WEST SUSSEX COUNTY COUNCIL CONSULTATION

TO:	Arun District Council FAO: Anita Gardner
FROM:	WSCC - Highways Authority
DATE:	21 July 2021
LOCATION:	68 Ancton Way Bognor Regis PO22 6JP
SUBJECT:	M/92/21/PL Demolition of existing bungalow & construction of 1 No 2-storey dwelling with access & off road parking. This site is in CIL Zone 4 & is CIL Liable as new dwelling.
DATE OF SITE VISIT:	n/a
RECOMMENDATION:	Advice
S106 CONTRIBUTION TOTAL:	n/a

PROPOSED PLOT PLAN

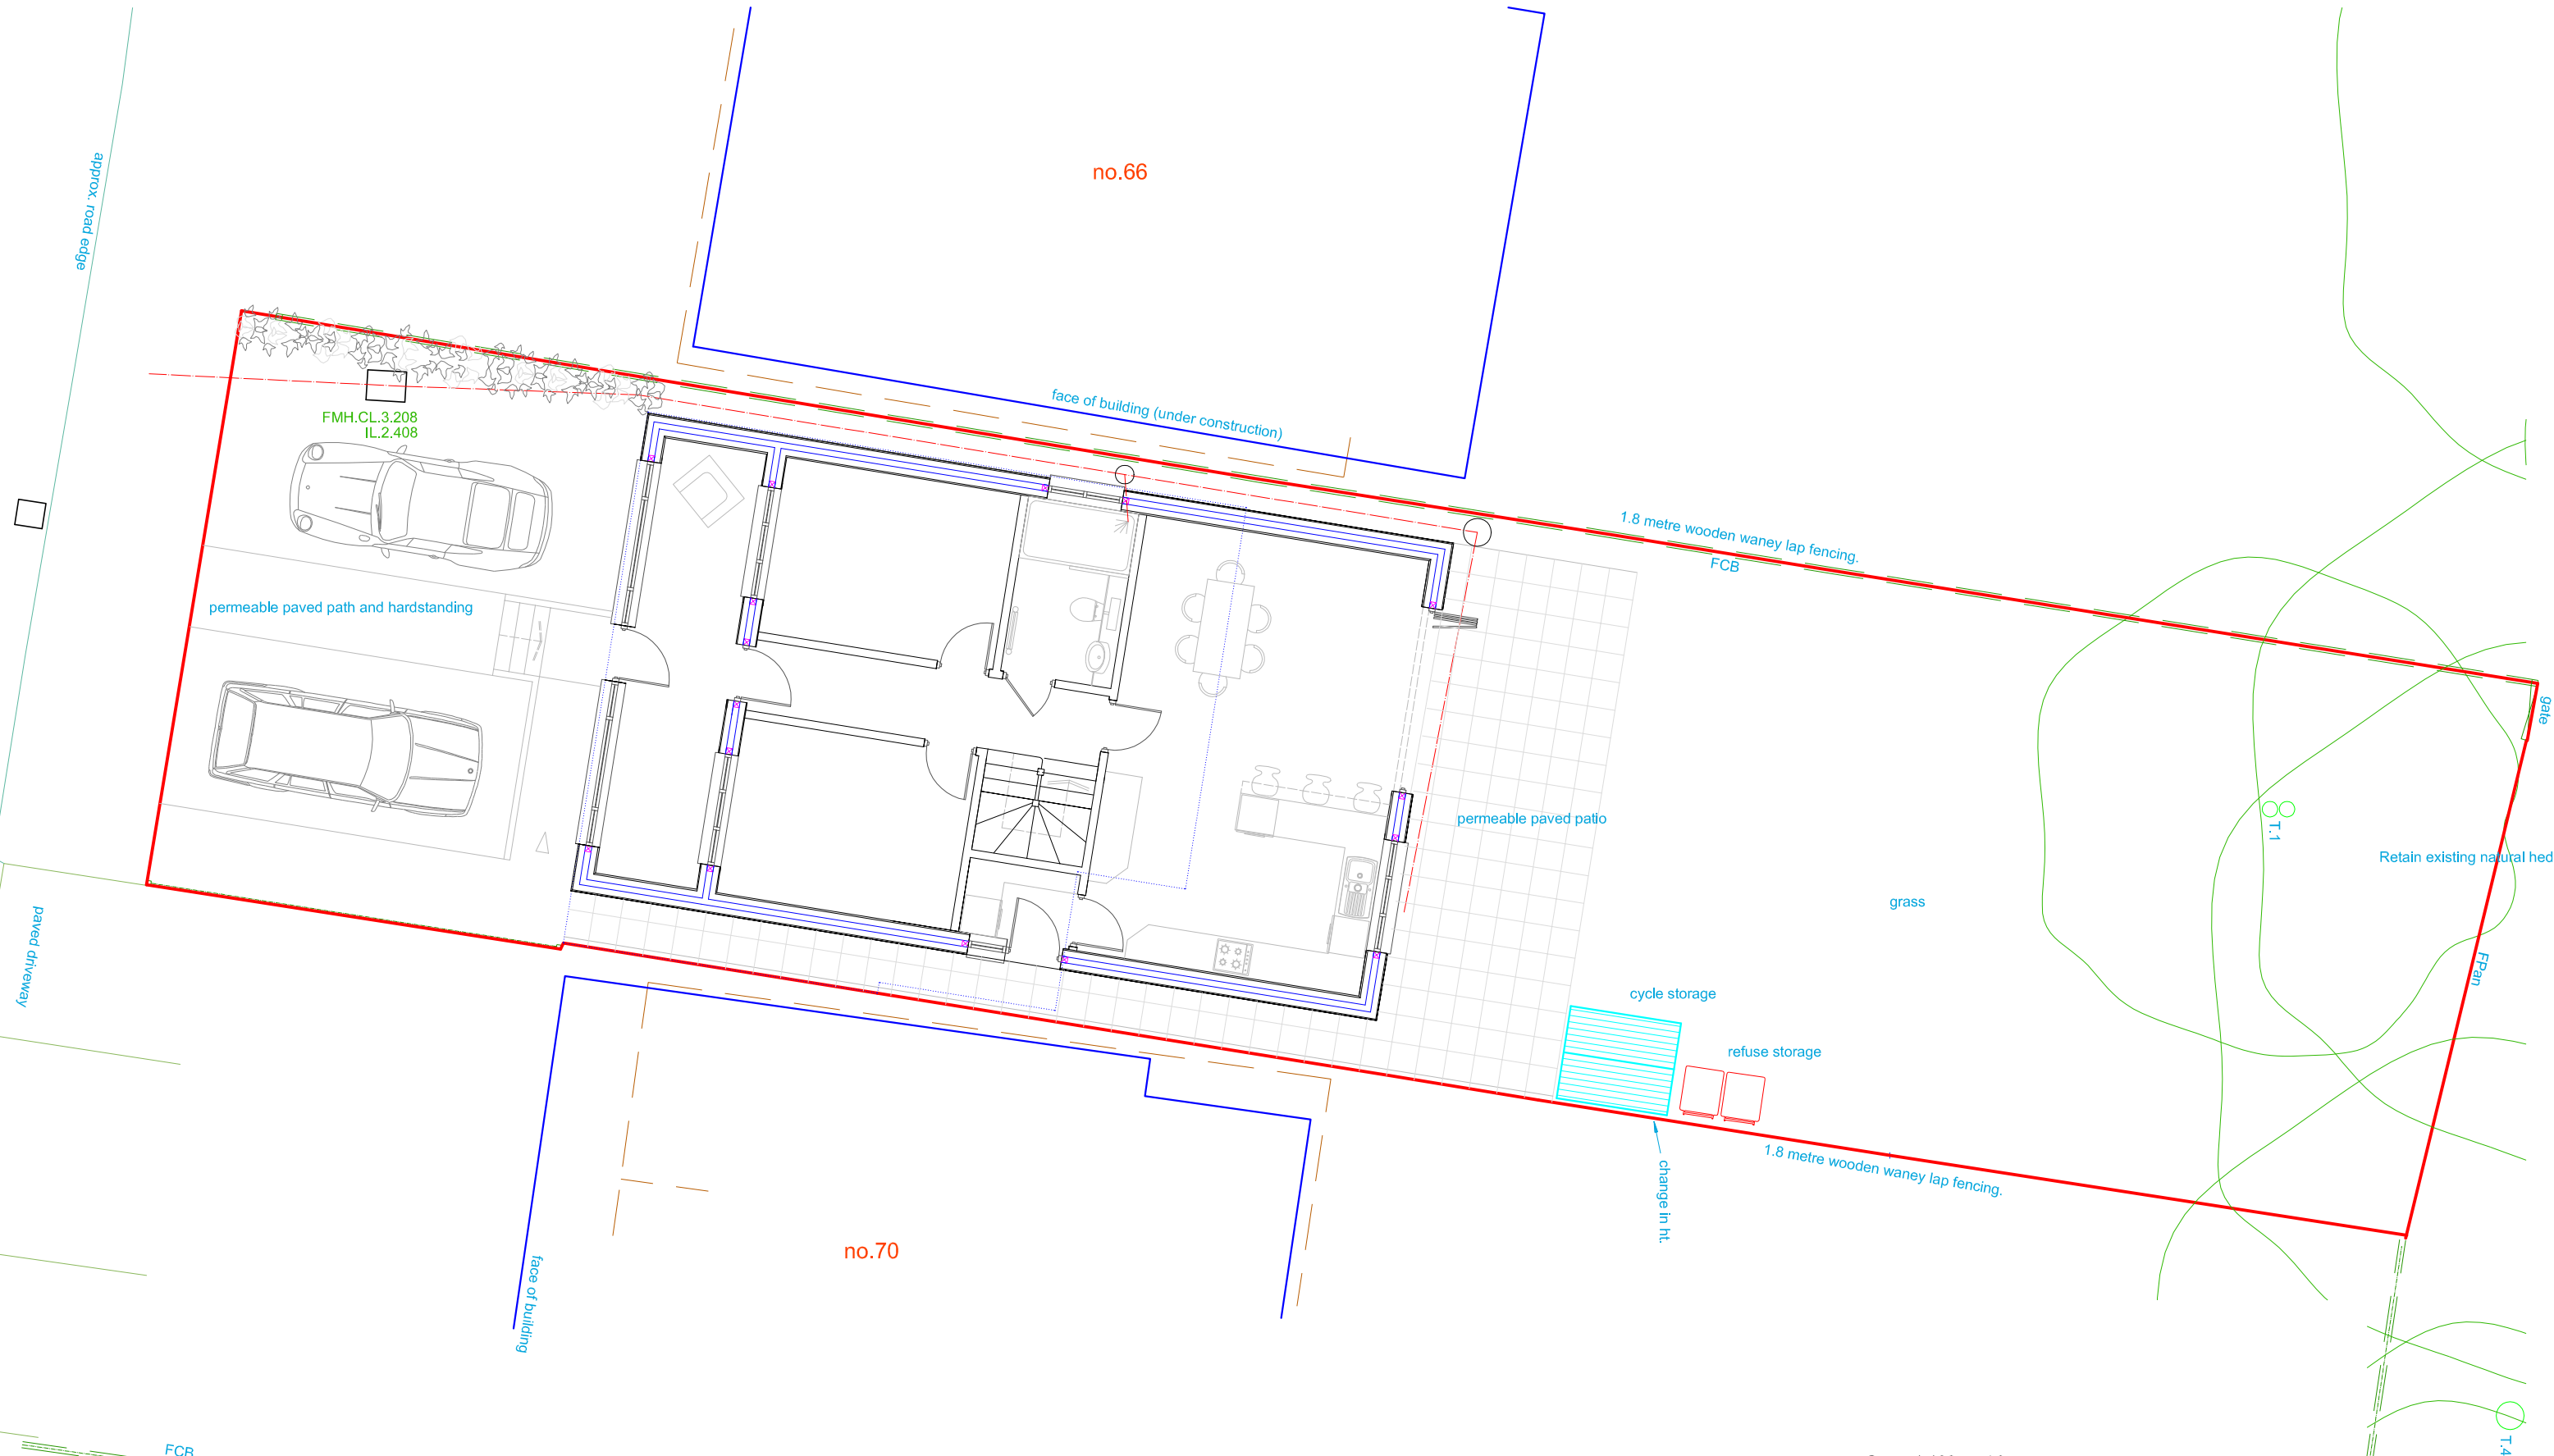
The plans demonstrate that 2 parking spaces will be provided on site. Under Arun Parking Standards (adopted January 2020), the LHA would anticipate that 3 parking spaces would be required for a 4-bedroom dwelling in this location. The LHA would not raise any highway safety concerns with regards to the proposed parking provision, however the LPA may wish to consider the potential impacts of any overspill parking generated from the proposal on on-street parking from an amenity point of view.

The proposed plans demonstrate secure and covered cycle storage in the form of a shed. This is anticipated to provide sufficient storage space for cycles associated with the dwelling.

No part of the development shall be first occupied until the car parking has been constructed in accordance with the approved site plan. These spaces shall thereafter be retained at all times for their designated purpose.

No part of the development shall be first occupied until covered and secure cycle parking spaces have been provided in accordance with the approved plan.
